Our Ref: BE/87/17/NMA

Application for A Non-material Amendment Following a Grant of Planning Permission

Development Application for a non- material amendment following the grant of BE/45/16/PL relating to alterations to elevation treatments, change of roof pitch & changes to window style.

Location 27 North Bersted Street Bognor Regis

DRG TITLE
Type 01a (proposed)
Bungalow Plans

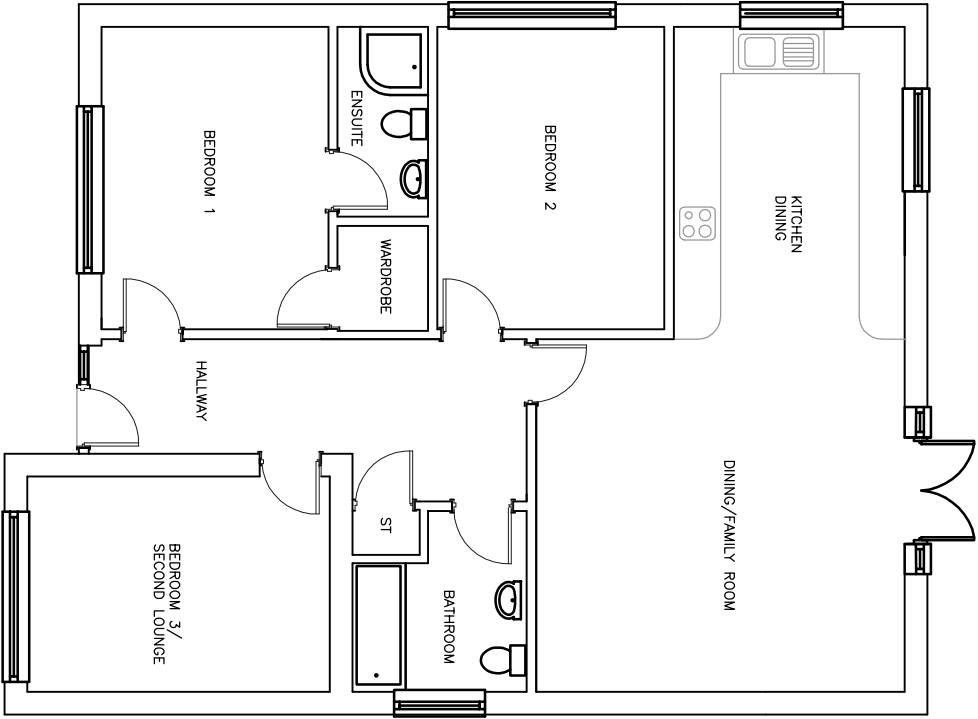
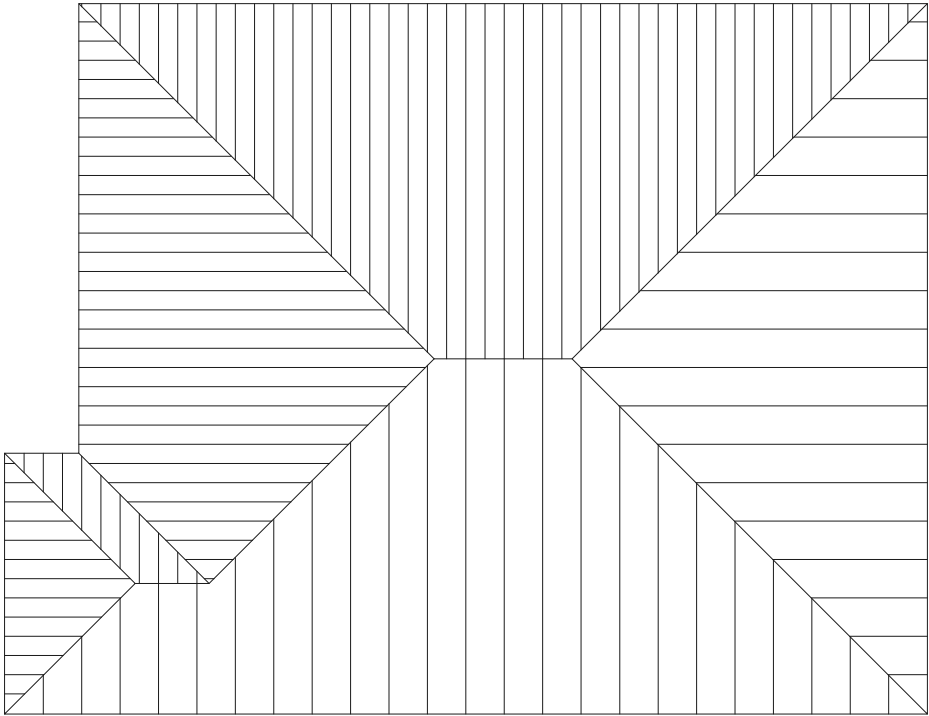
Plans 5013 and 5014 (proposed Type 01(a). SE elevation and floor plan do not accord. Please amend accordingly.

Type 03 (proposed)
House Plans

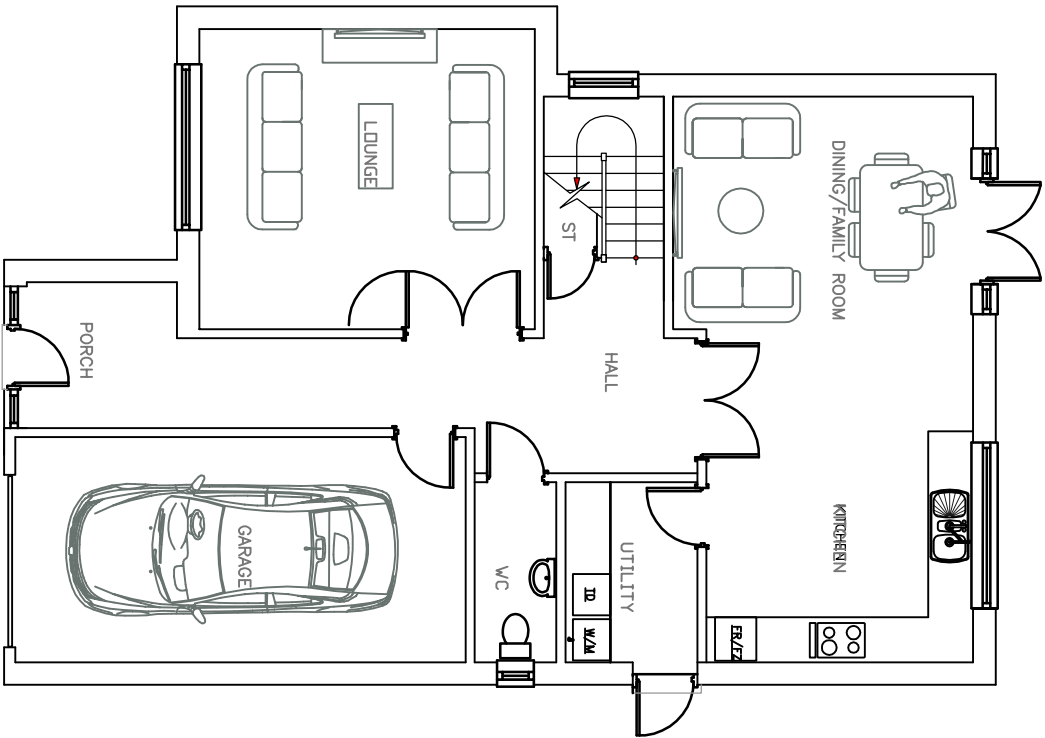
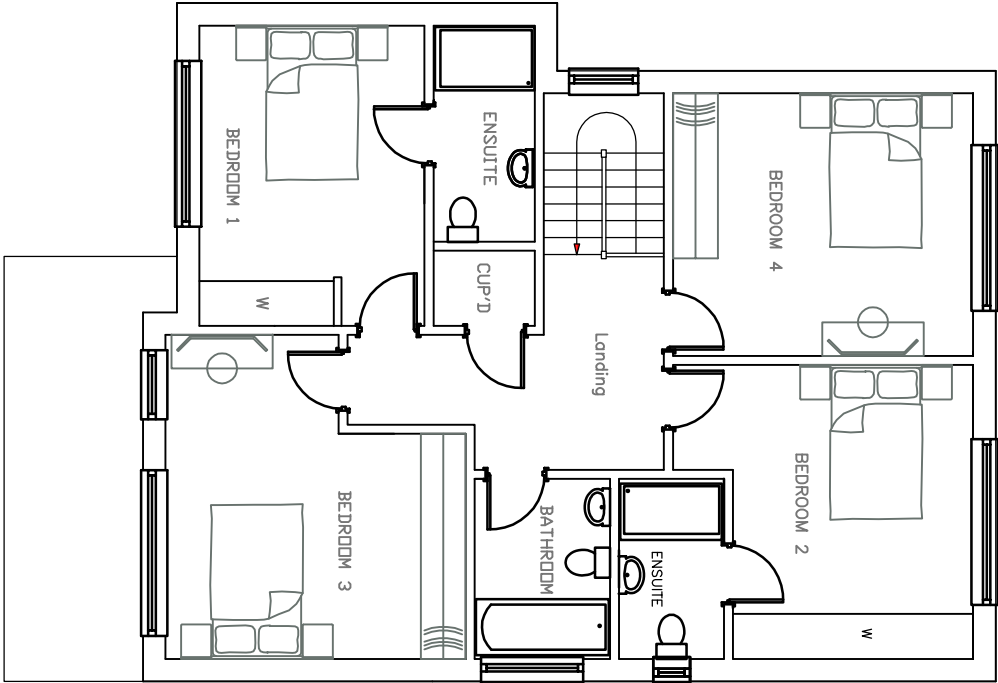
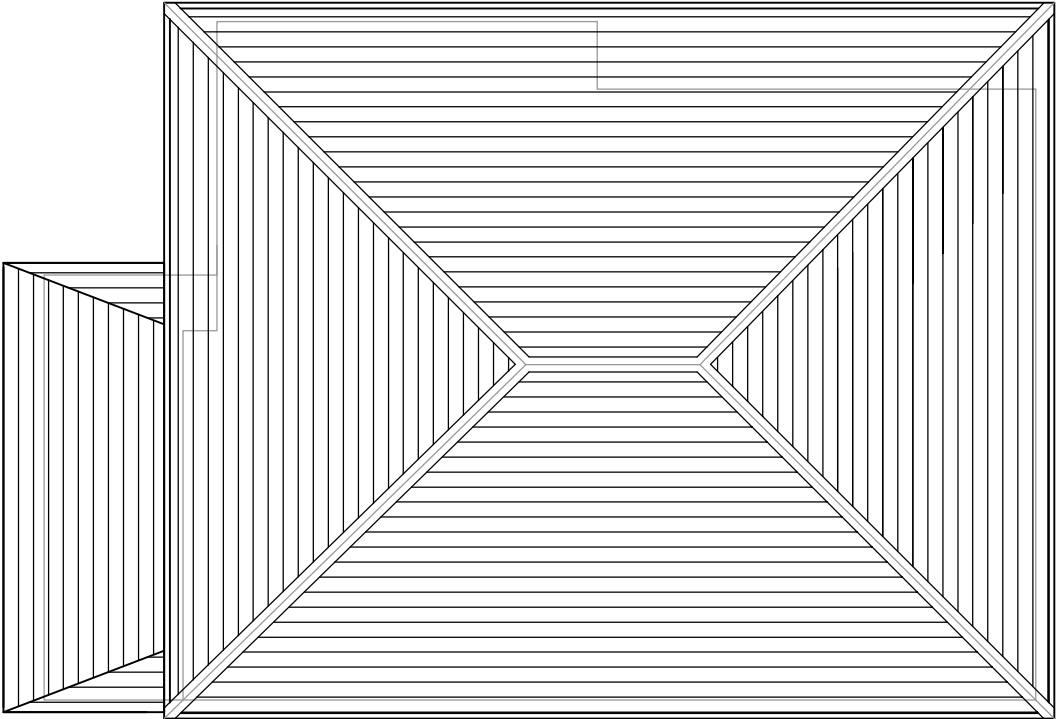
Plans 5017 and 5018 (proposed Type 03) floor plans and elevations do not accord. Please amend accordingly.
